DELEGATED DECISION TO DETERMINE PLANNING APPLICATIONS

Reference No:	2023/62/93502/W
Site Address:	100-102, Northgate, Huddersfield, HD1 6AR
Description:	Change of use from first floor and attic office (Eciii) to form 4 apartments (C3); erection of rear dormer extension at attic level and first floor extension to raise the roof of existing warehouse (B2/Eciii) to create additional storage space
Recommending Officer:	Lucy Taylor

DECISION – REFUSED

Project Title
existing and proposed longitudinal section

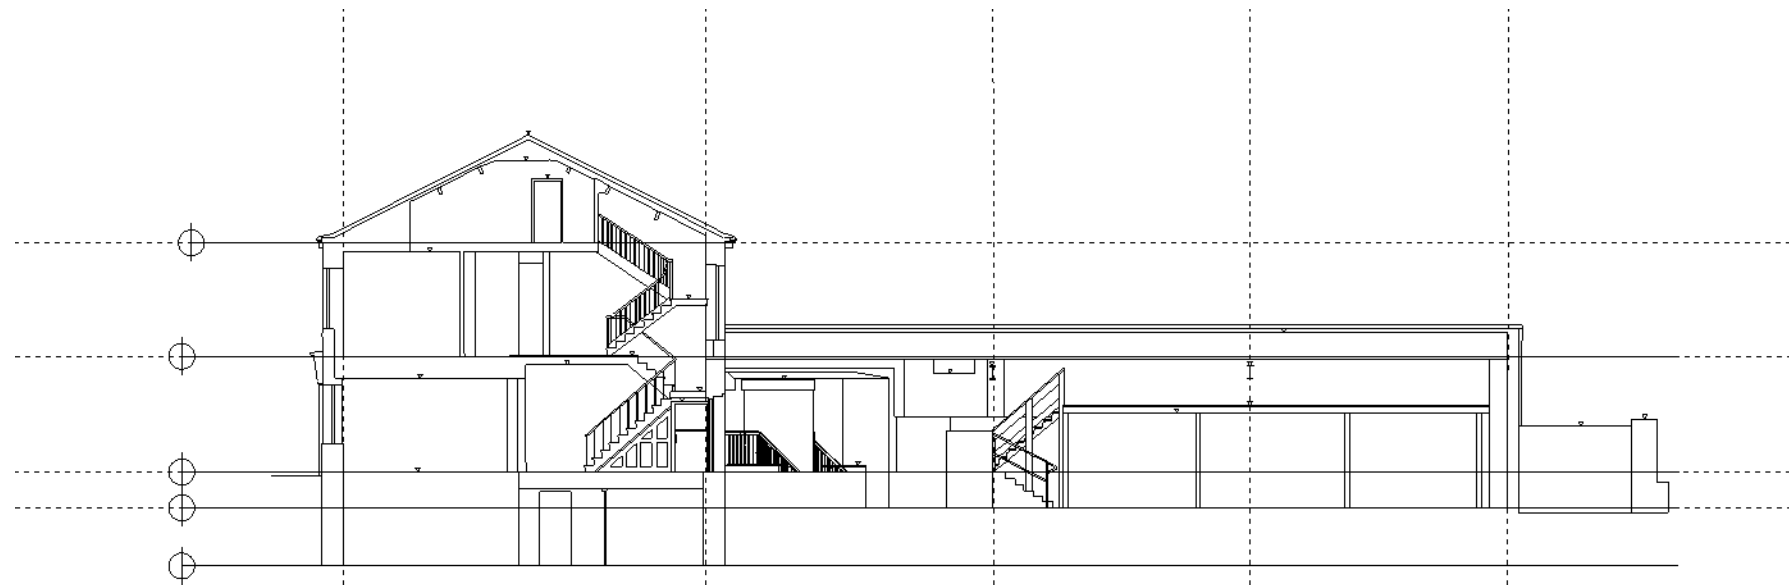
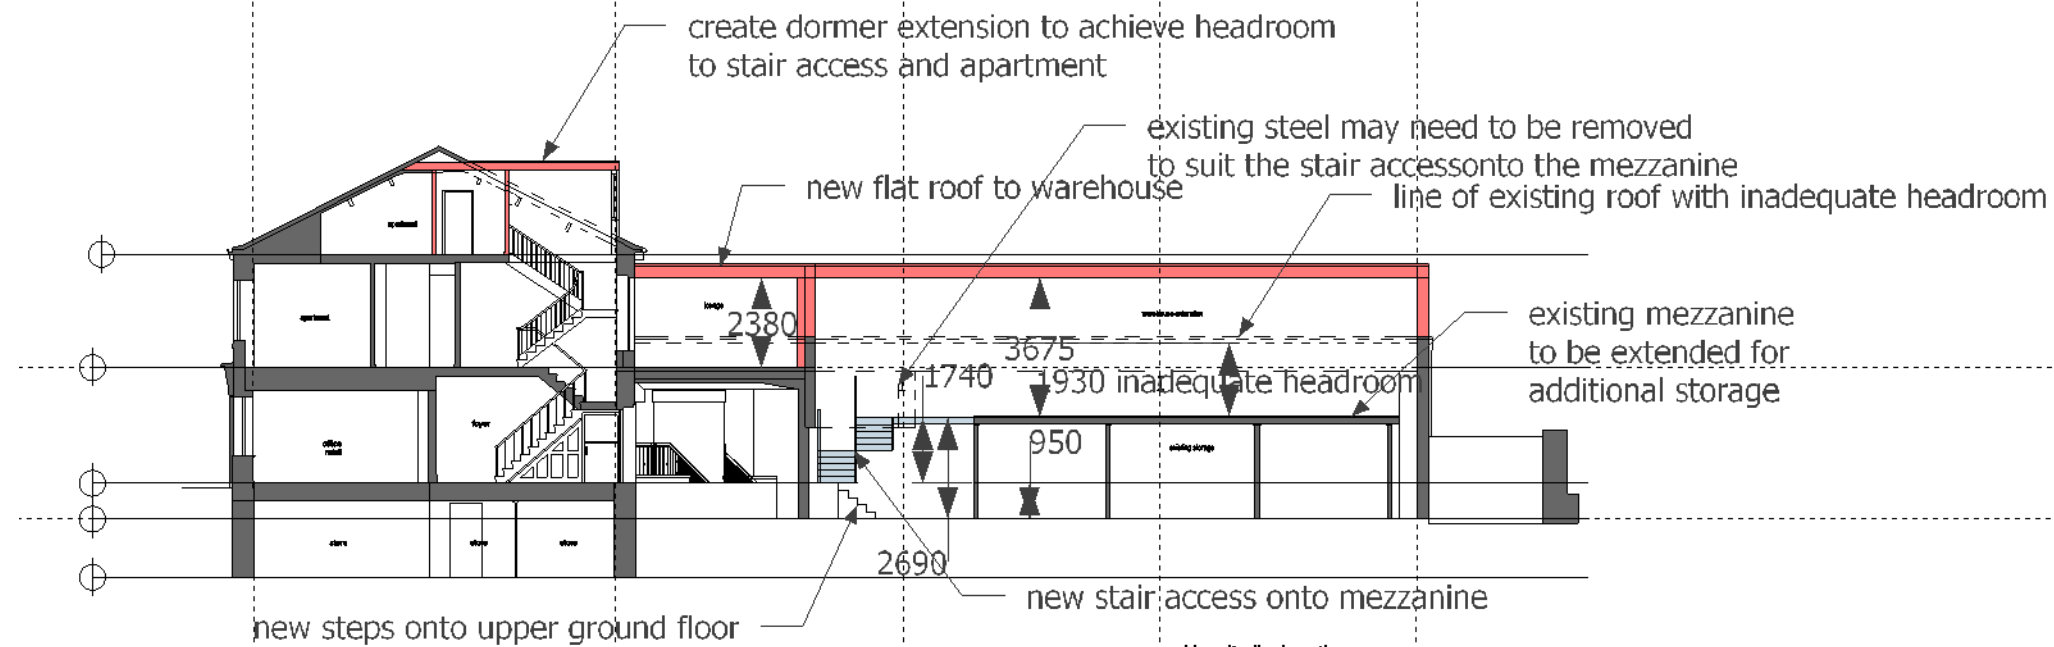
It is concluded that, cumulatively, the proposed dormer and first-floor extensions would result in an undue extent of bulk and massing, with the

The northern elevation of the first-floor extension is to be blank, solid stone. This would further exacerbate the prominent and stark appearance of the extension from the highway of Northgate, adding a dominating first-floor element in a clearly visible location.

The southern elevation of the first-floor extension is considered to introduce harm visually, especially with regards to the large expanse of metal cladding proposed. Whilst it is acknowledged that a small amount of metal cladding is present to this elevation at ground floor level at present, the use of it as part of the extension would be significantly more prominent given its elevated position and would be applied in much greater quantities.

Furthermore, the addition of a flat roofing form at first floor level is considered to be a design element that is out of keeping with the host building and surrounding area, with the host building, adjoining building and properties in the immediate area characterised by tiled gable roofs.

The dormer fails to be set subserviently to the roof of the host building, it is set down from the roof pitch by only approximately 0.3 metres and is set up from the eaves by only approximately 0.3 metres.

Project Title
existing elevations

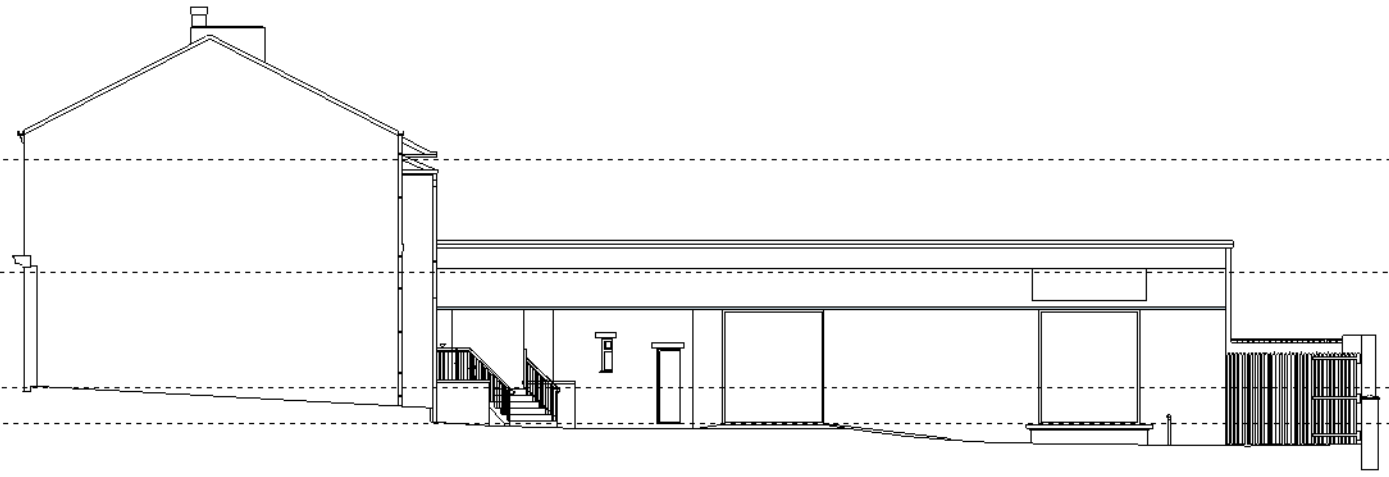
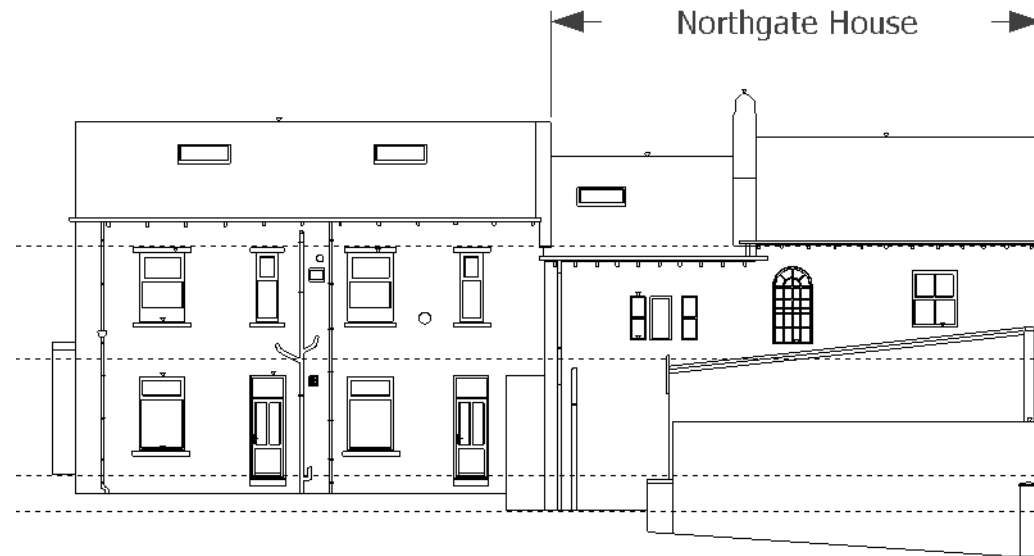
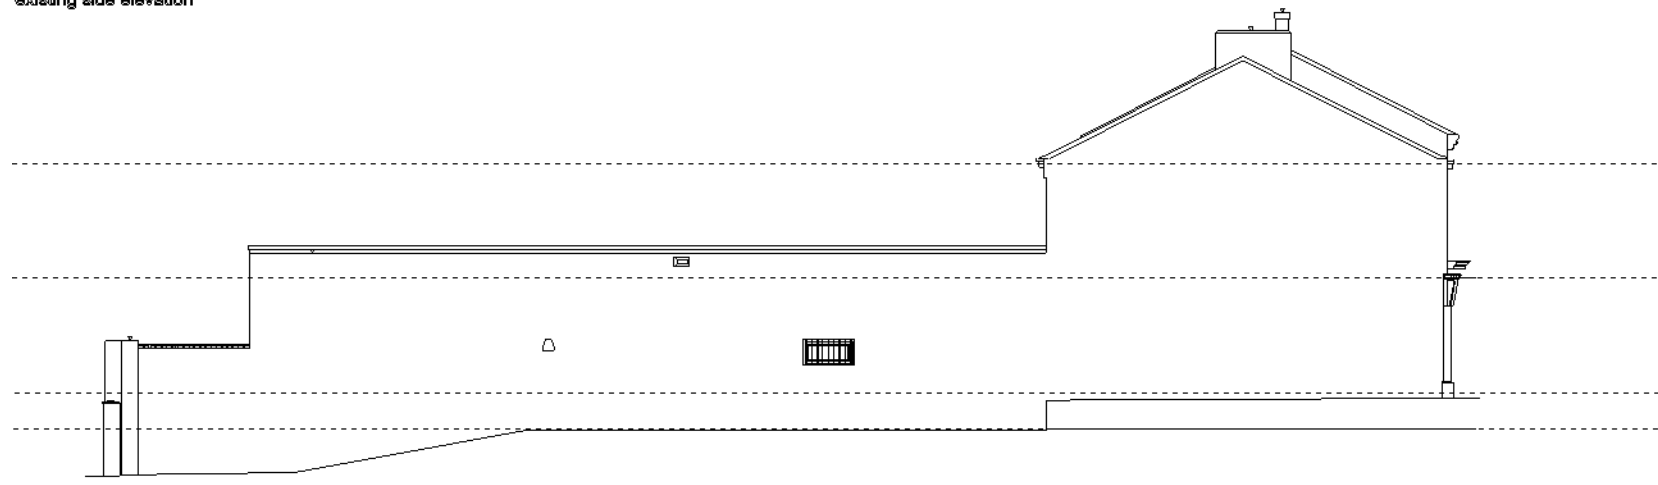
Both the dormer and first-floor extension would be clearly visible from several viewpoints within the streetscene, especially when the fronting highway of Northgate is travelled in a southern direction and when the highway of Castlegate is travelled both east and west.
